Application for Removal or Variation of a Condition following Grant of Planning Permission or  
Listed Building Consent

Erection of a single storey building for use as a place of worship with associated parking, landscaping, boundary treatments and access

22/02704/PLF

10 - drainage  
15 - approved plans

Drawn	AD	Chkd	RT	Date	Dec 2023	Scale	AS SHOWN @ A1
Sheet Size	A1	Drawing No.	23580-DR-C-0100	Revision			P6

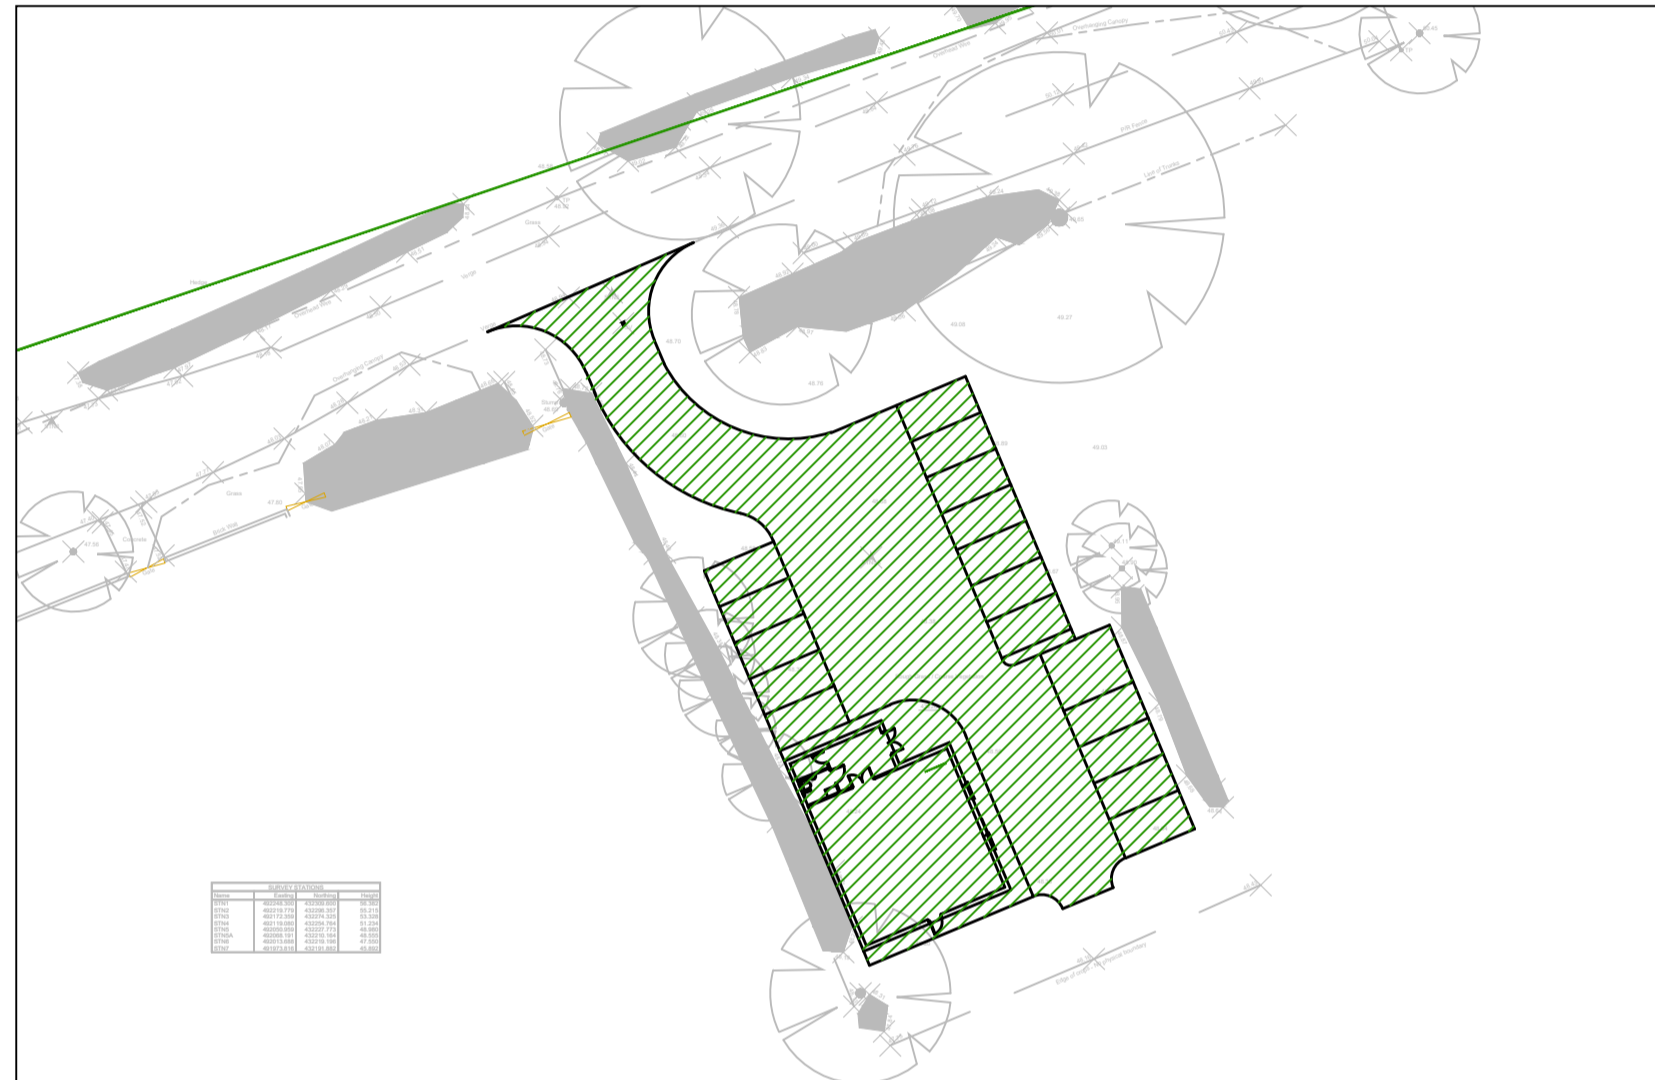
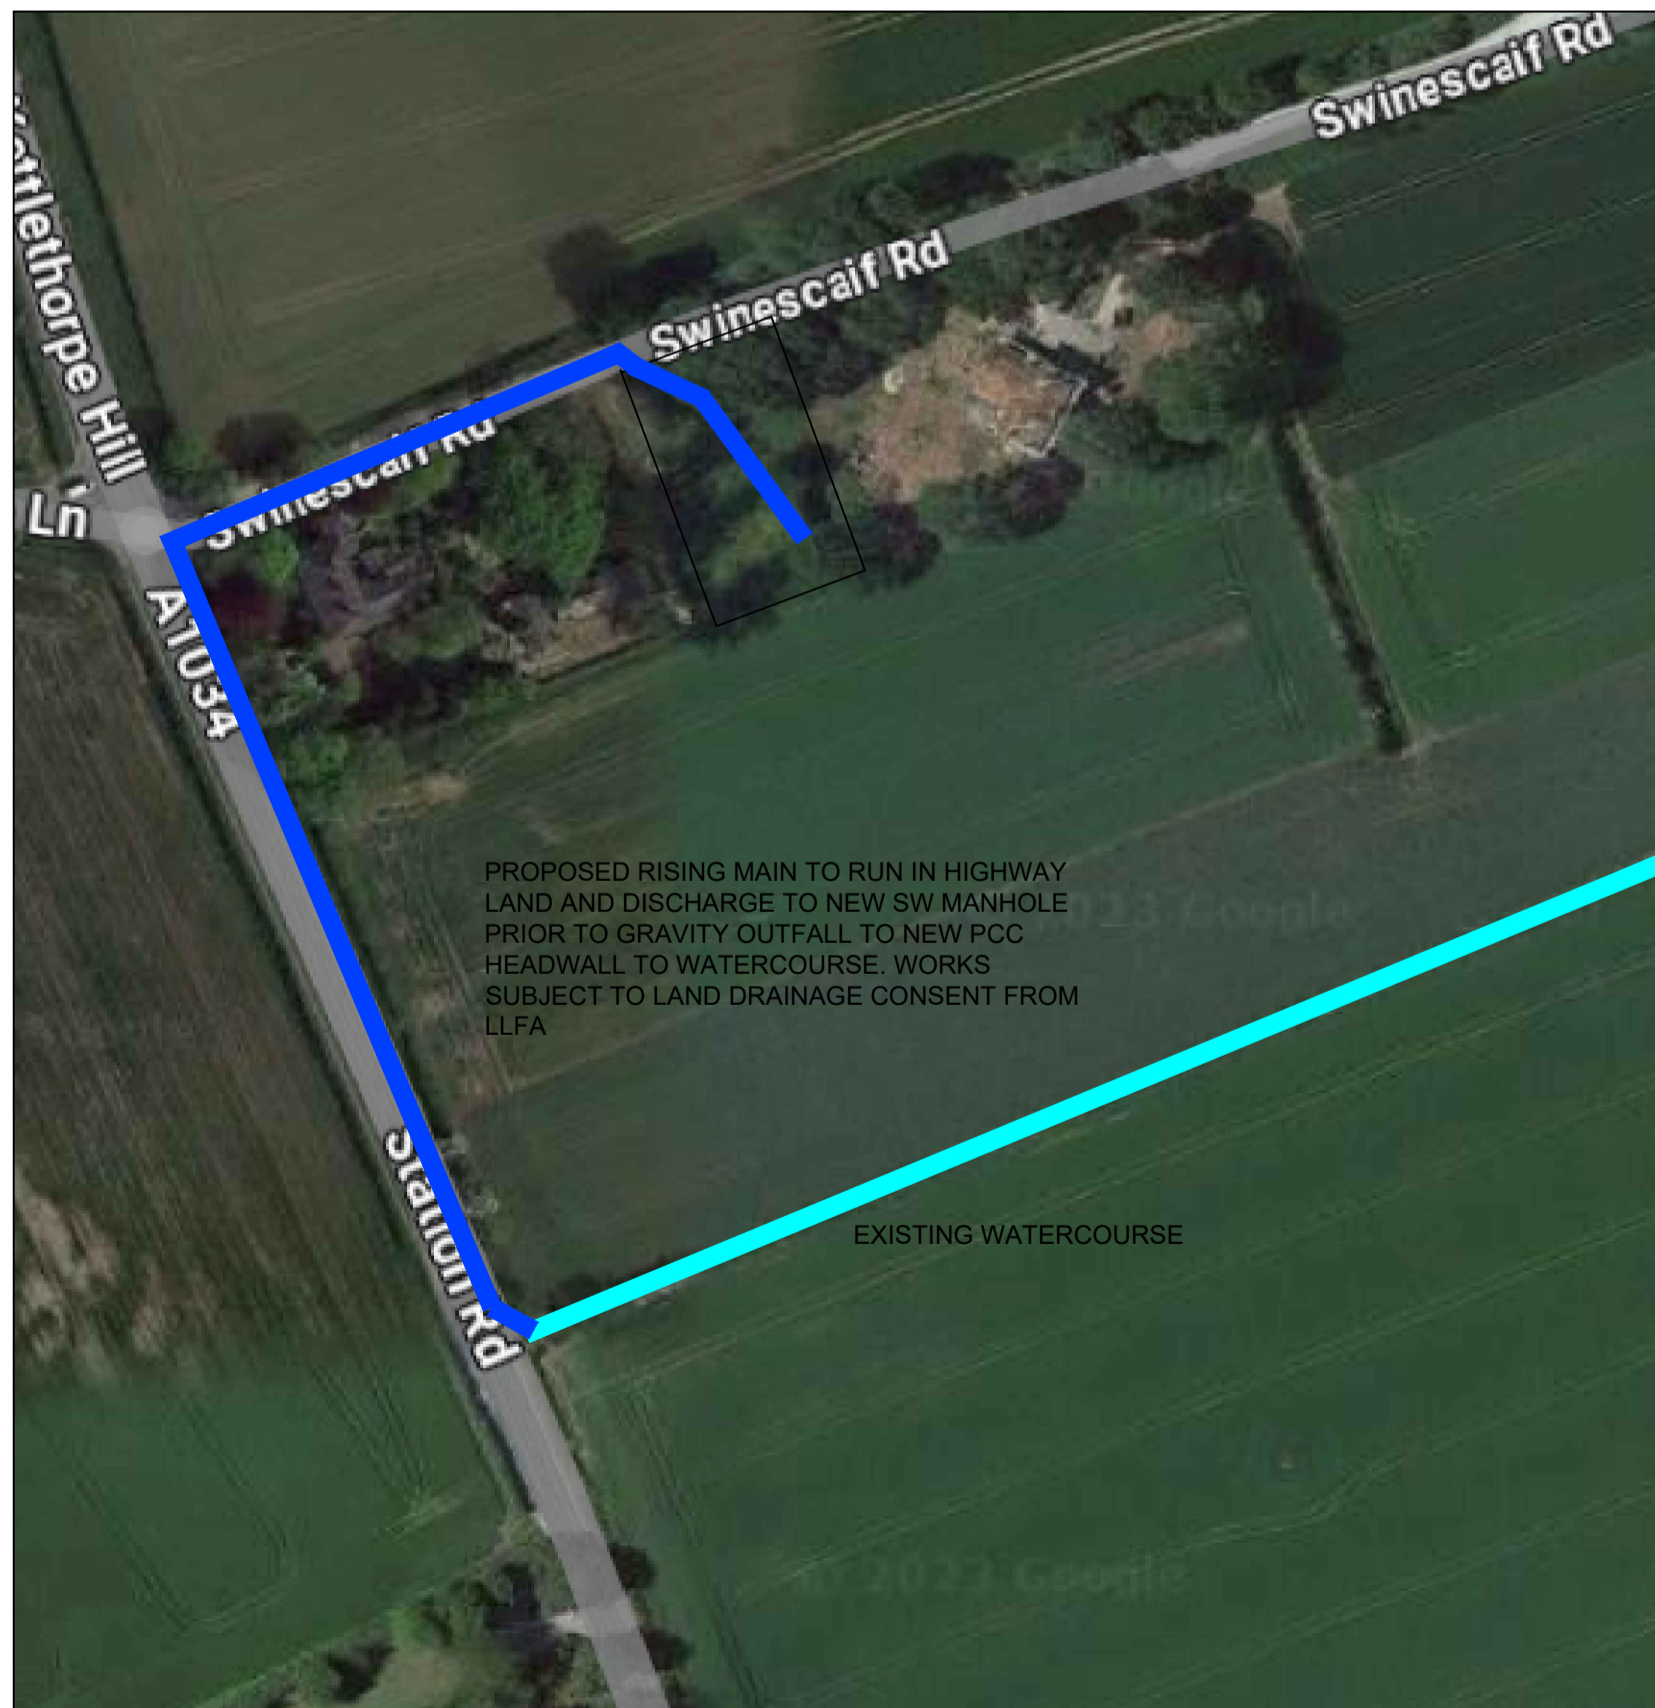
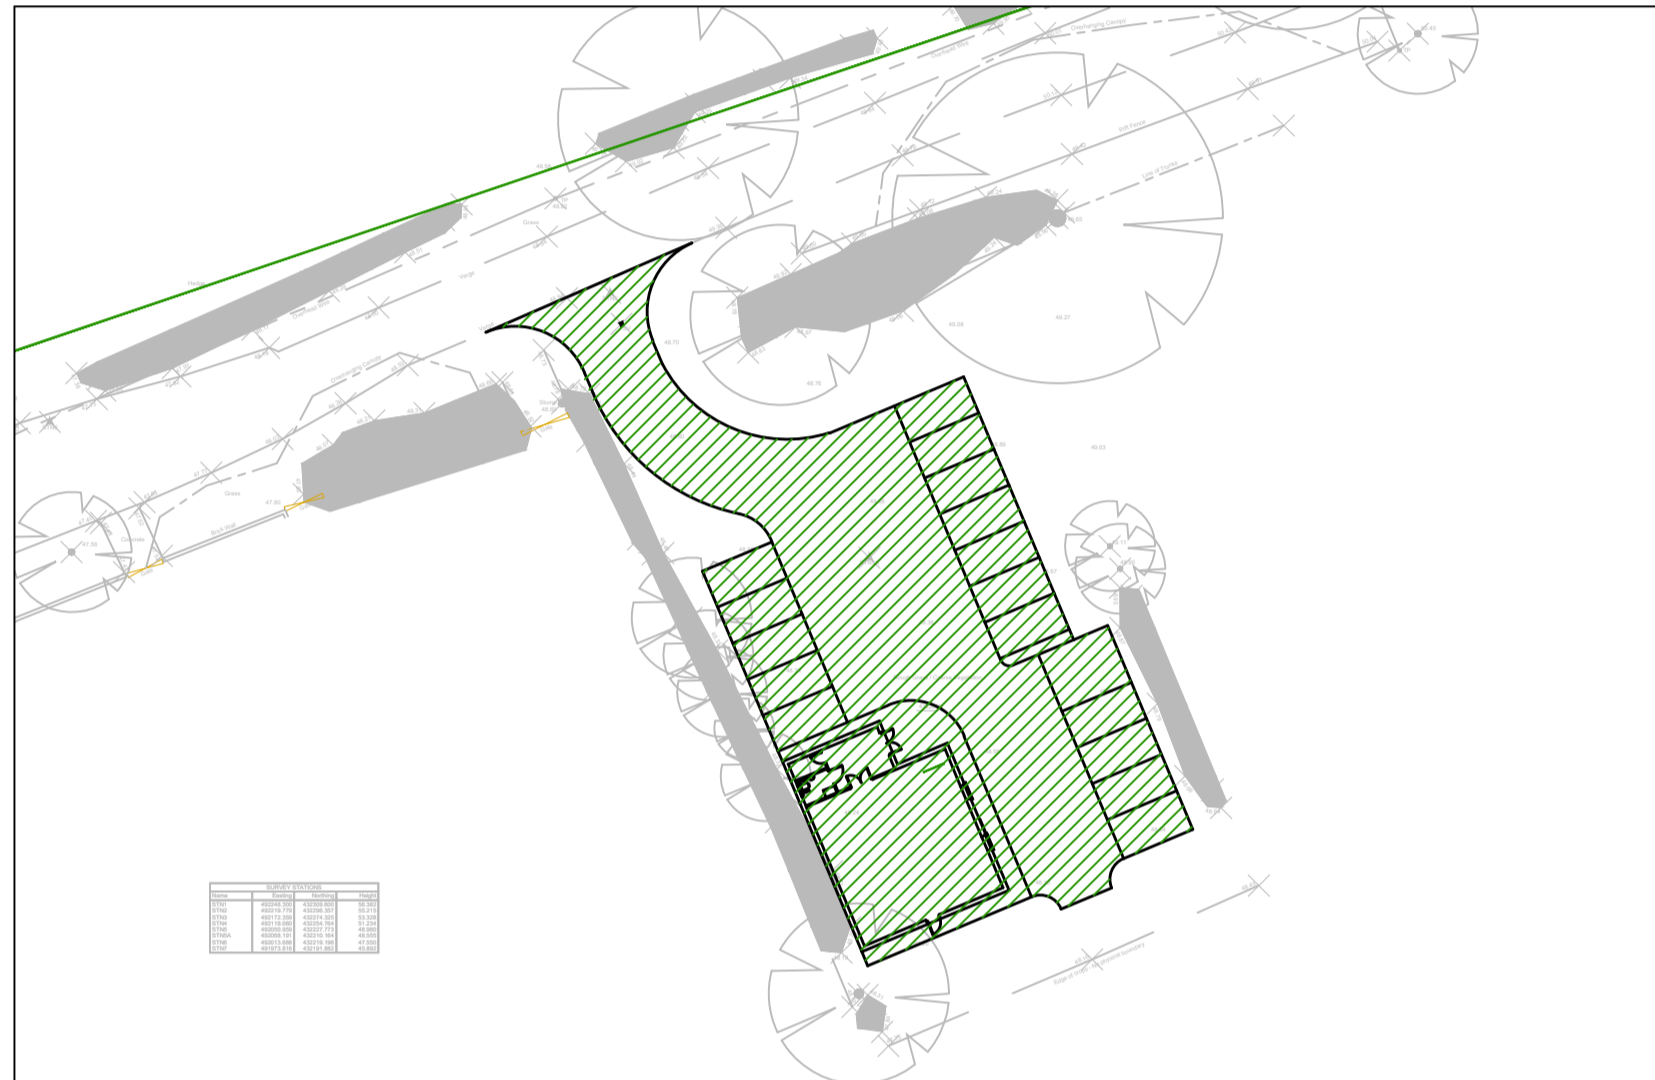
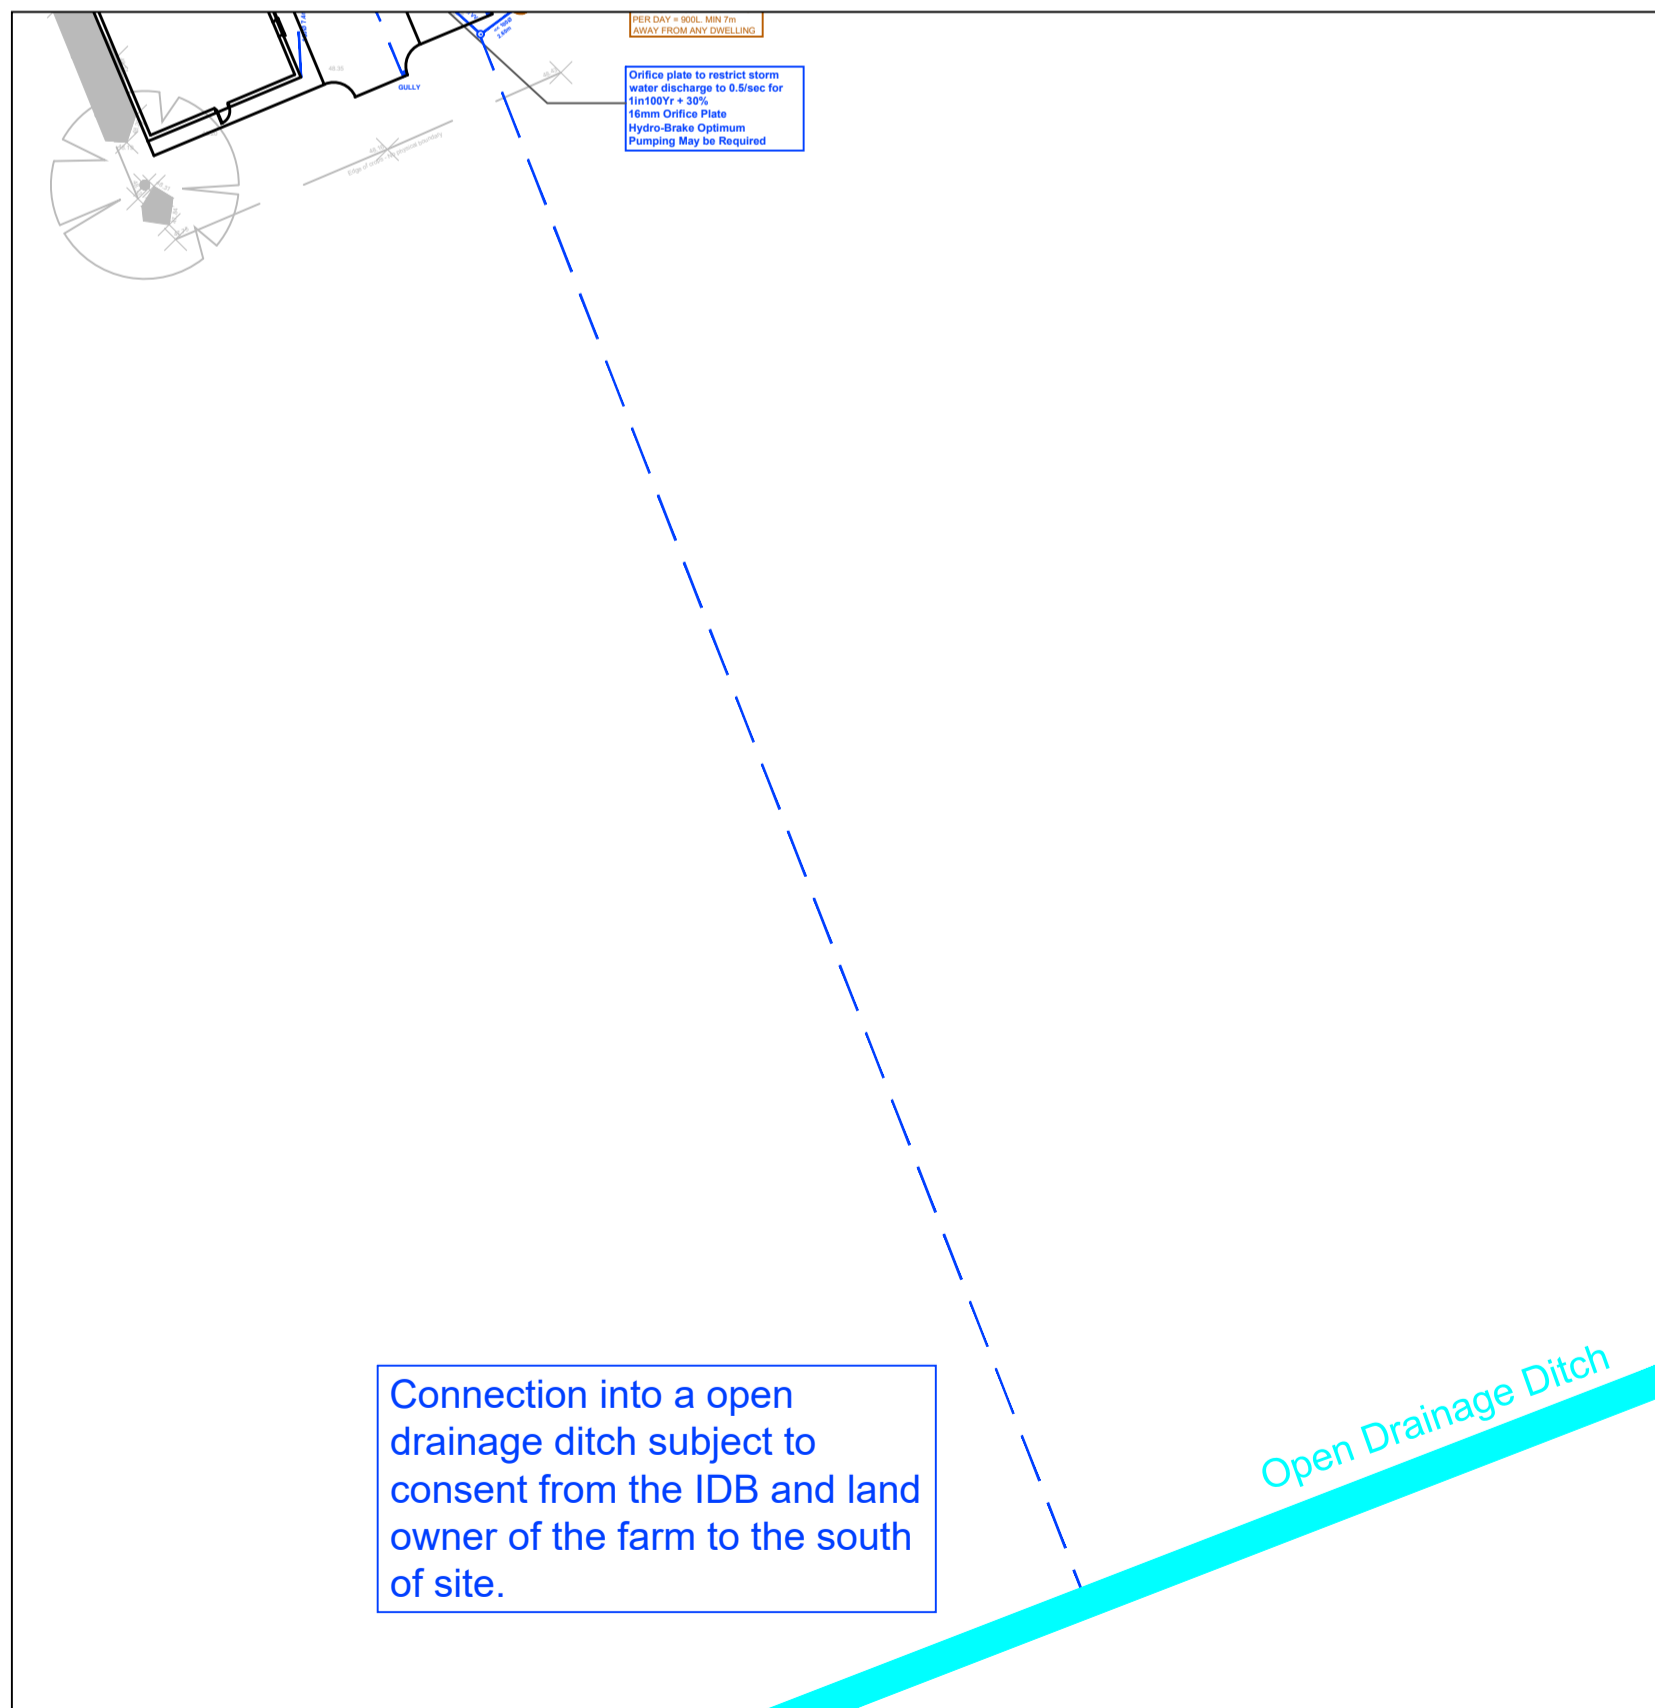
Drainage route: original proposed route for connection into drainage ditch is not possible. Revised route to same drainage ditch proposed.  
Cess tank: further to extensive research it has not been possible to find a sewage treatment plant that would work due to the infrequent and low usage of the foul drainage system. Cess pit proposed instead of treatment plant.

Drainage Strategy shown on drawing 23580-DR-C-0100 Rev P6 (included with this application) to replace that shown on drawing 23580-DR-C-0100 Rev P2 (as originally approved)
